Staffordshire County Council response to ExA's First Questions

Ref:	Question to:	Question:	SCC Response:
11.4	Applicant DCC Staffordshire County Council (SCC)	Heavy goods vehicles (HGV) Paragraph 5.14.14 of NPS EN-1 states that requirements may be added to a consent where there is likely to be substantial HGV traffic that control numbers and possibly routing of HGV movements in a specified period during construction; make sufficient provision for HGV parking and facilities; and ensure satisfactory arrangements for reasonably foreseeable abnormal disruption. Paragraph 2.10.123 of NPS EN-3 states that Applicants should assess the various potential routes to the site for delivery of materials and components where the source of the materials is known at the time of the application and select the route that is the most appropriate. Paragraph 2.10.125 includes that Applicants should ensure all sections of roads and bridges on the proposed delivery route can accommodate the weight and volume of the loads and width of vehicles. Where modifications to roads and/or bridges are required, these should be identified, and potential effects addressed. DCC [RR-078] considers that further assessme

Figure 10.4: Scenario 2B Back-up Construction Vehicle Routing

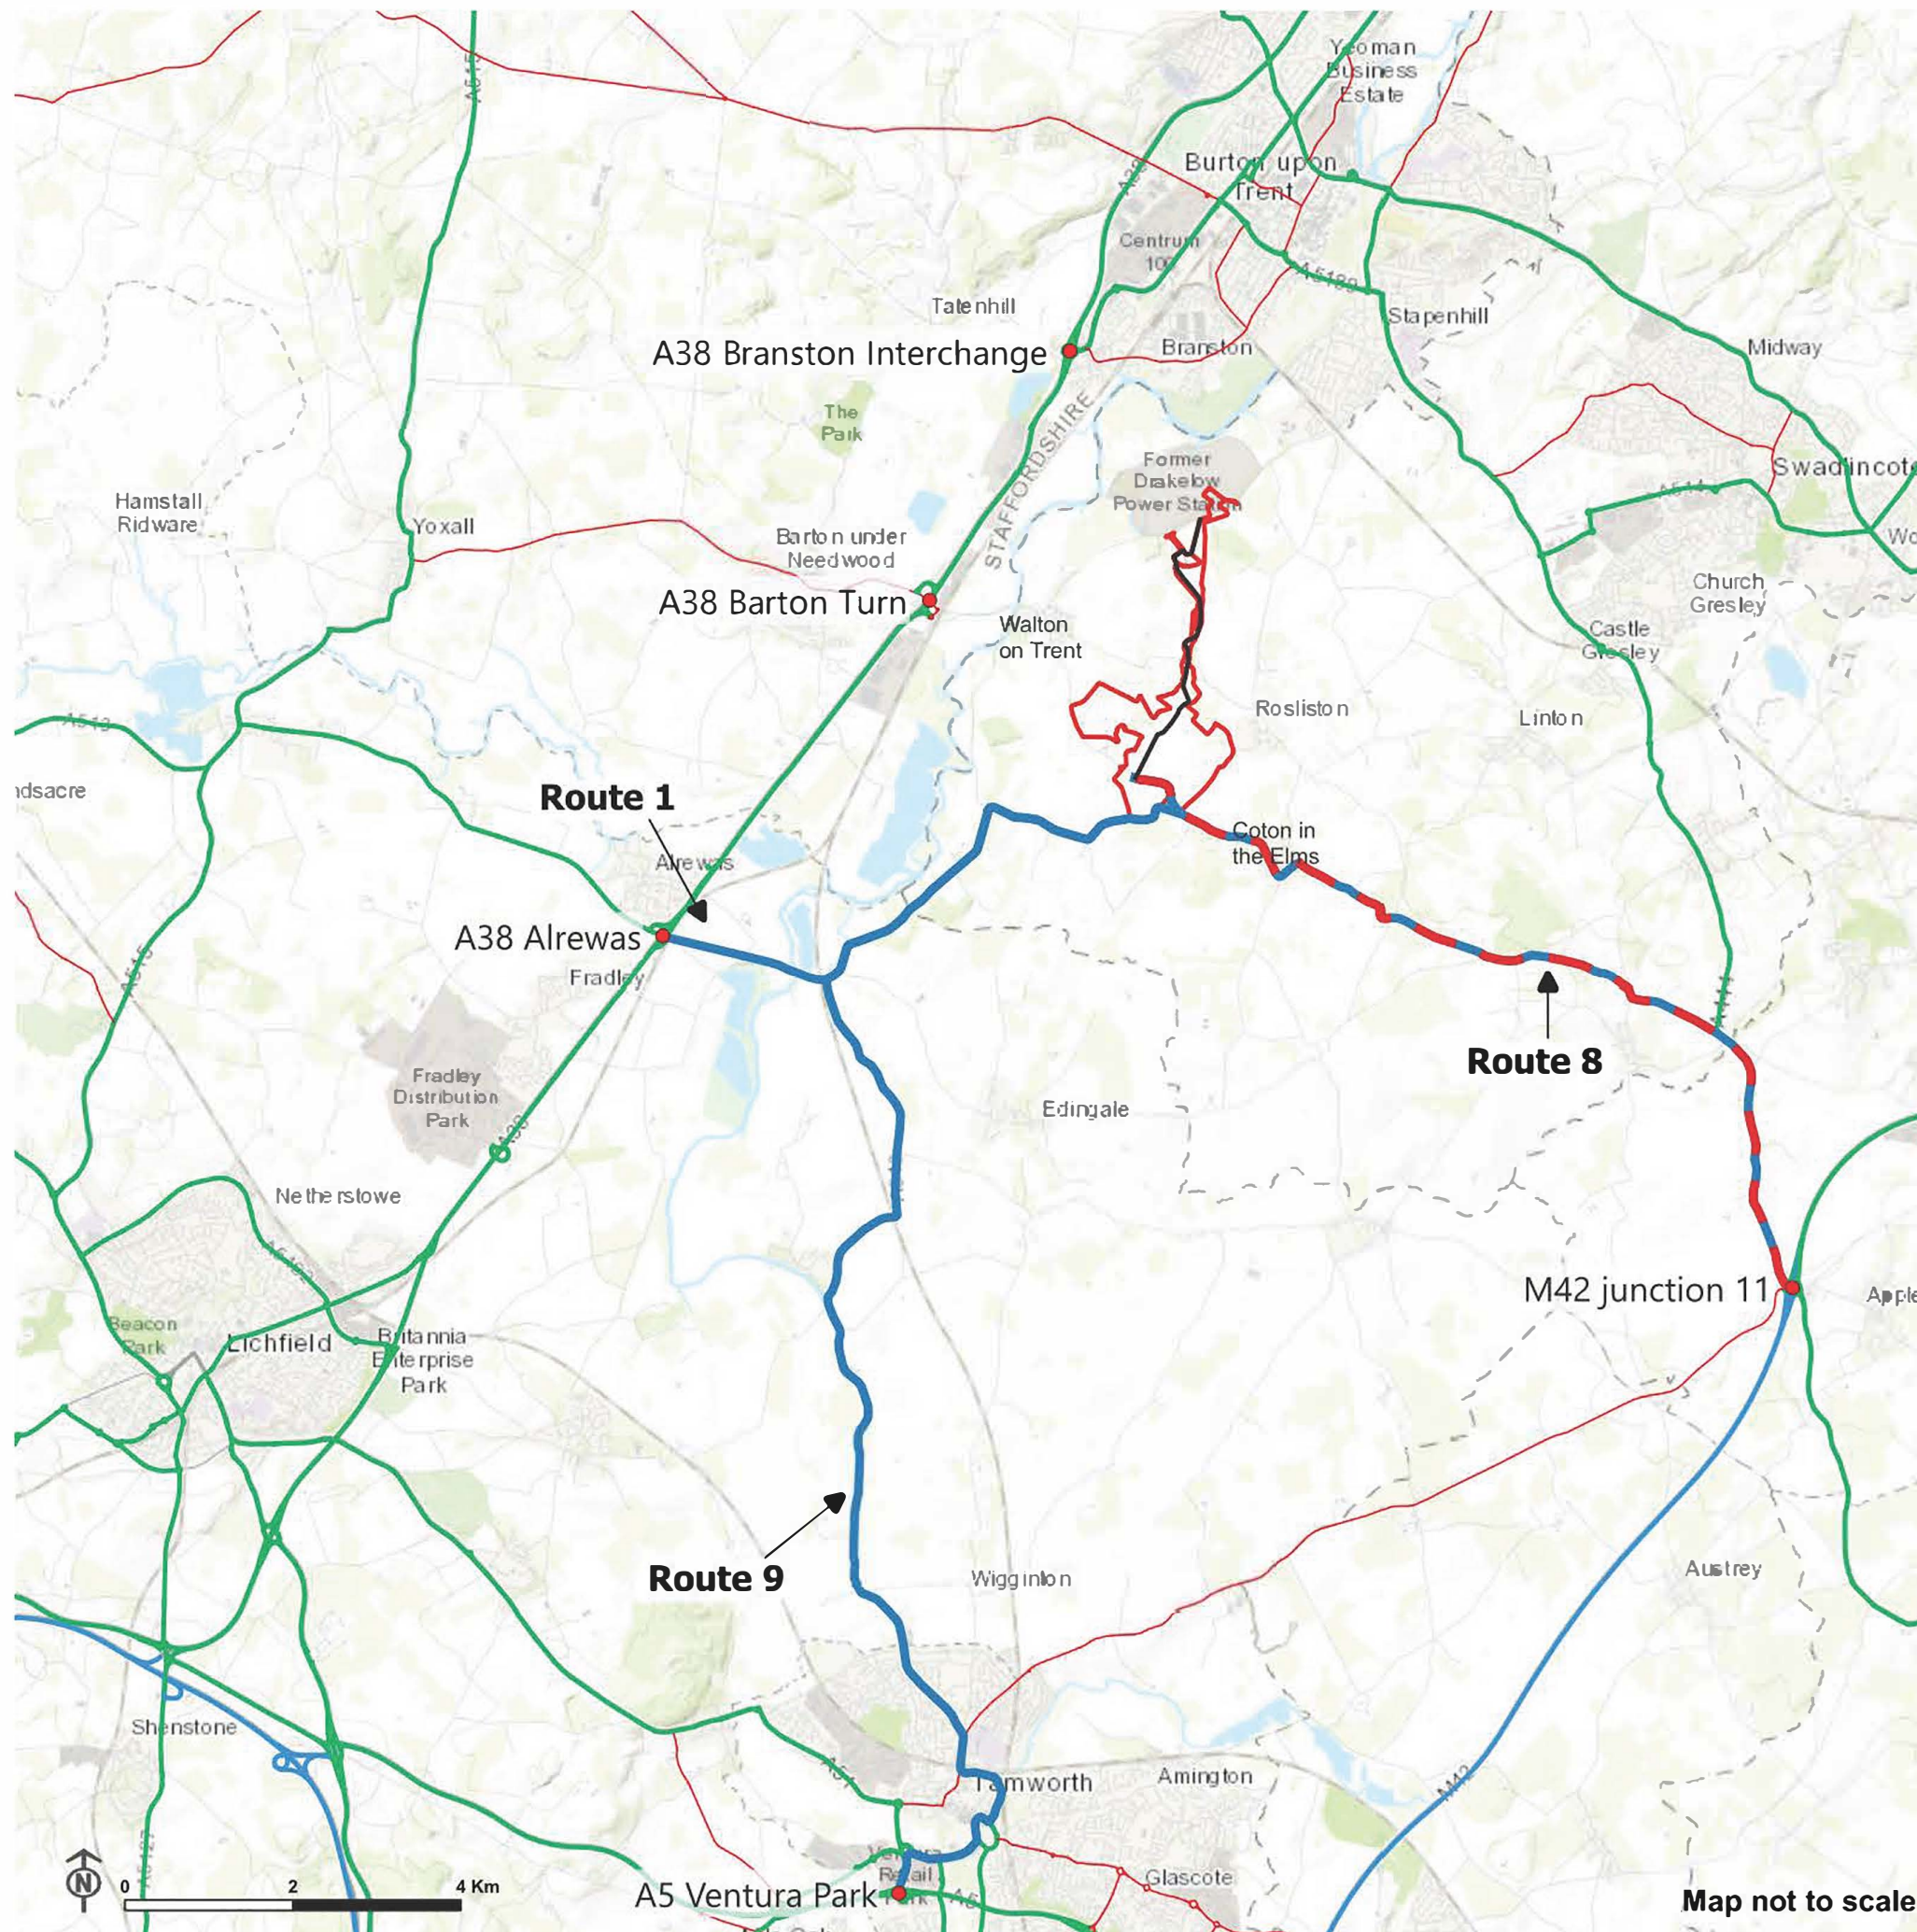
<p>e) Should it be secured that construction route Scenario 2B would only be used if Scenarios 1 and 2A are not available?</p> <p>f) Are any more measures required to ensure that no construction traffic would go through Walton-on-Trent?</p> <p>g) Are there any concerns about whether sections of roads and bridges on the proposed routes can accommodate the weight and volume of the loads and width of vehicles?</p>
